Consultation Response from: KC Environmental Health (Pollution & Noise Control)
2023/90739 - Land at Whitechapel Road, Cleckheaton

Discharge conditions 18 (Noise Mitigation), 19 (Acoustic Ventilation Scheme), 26 (Full Travel Plan), 28 (Phased Temp Waste Strategy), 29 (Waste Collection Points), 35 (Pumping Station Details), 37 (Artificial Lighting) on previous permission 2021/94498 for Variation of condition 2 (Plans and Specification), 5 (Materials), 9 (Diverted Footpath), 12 (BNGA), 13 (CEMP:Biodiversity), 14 (Arboricultural Impact and Method), 17 (Acoustic Barrier), 18 (Noise Mitigation) and 22 (Electric Vehicle Charging) on previous permission 2019/93658 for erection of 122 dwellings, landscaping and associated infrastructure

Responding Date:
11 July 2023
Responding Officer:
Mohammed Nasim
Responding Ref:
WK202316994
Comments

## APPENDIX 01 – GLAZING AND VENTILATION REQUIREMENTS

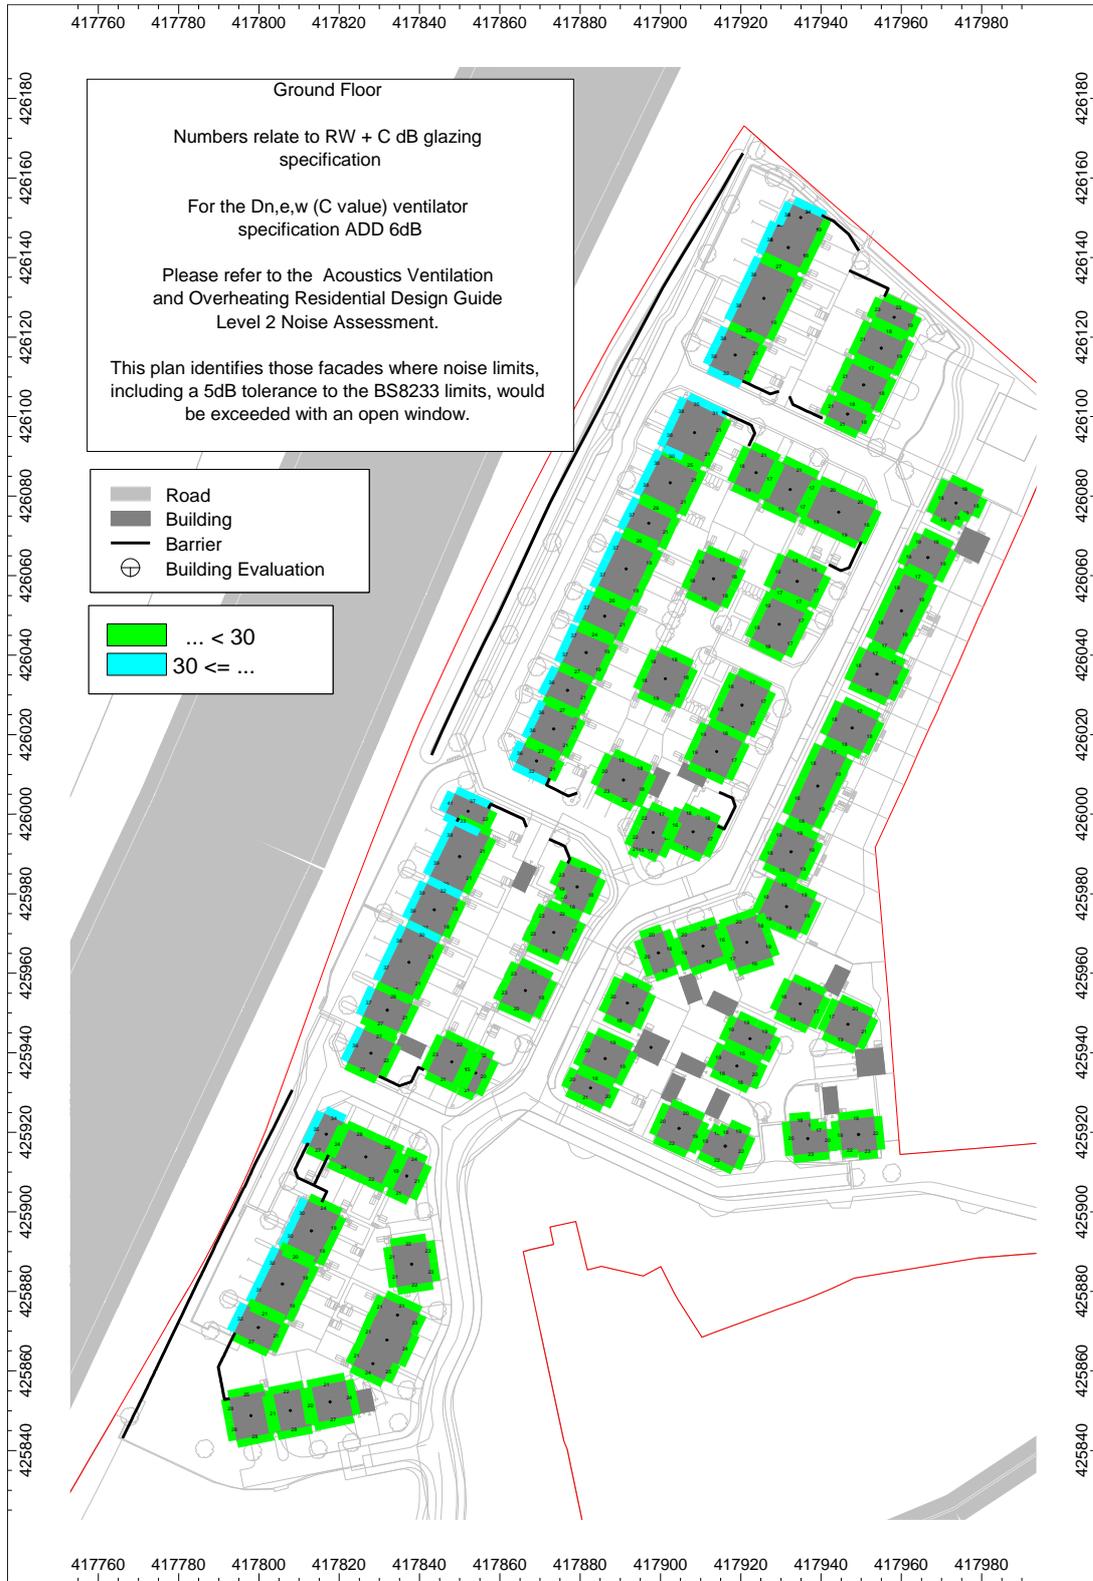
ventilation required in order for the development to meet with the internal requirements of BS8233 and this is reflected in the plans as shown in Appendix A.

The level of mitigation to each affected façade is colour coded and it is noted that all properties on the western edge of the development, closest to the M62, will be provided with a Mechanical Ventilation Heat Recovery system (MVHR). Therefore, trickle vents will not be required for these properties. The external amenity areas remain unchanged.

The findings of the addendum report are accepted. However, we recommend the condition is not discharged until all of the mitigation measures outlined in the Noise Assessment by SLR, (Ref: 405.03696.00038, version 10, dated April 2021 (cavity walls and roofing) and all of the mitigation measures outlined in the subsequent Noise Addendum report by SLR (Ref 403.064816.00001) dated 18 May 2023 (glazing and ventilation) are implemented and retained thereafter.
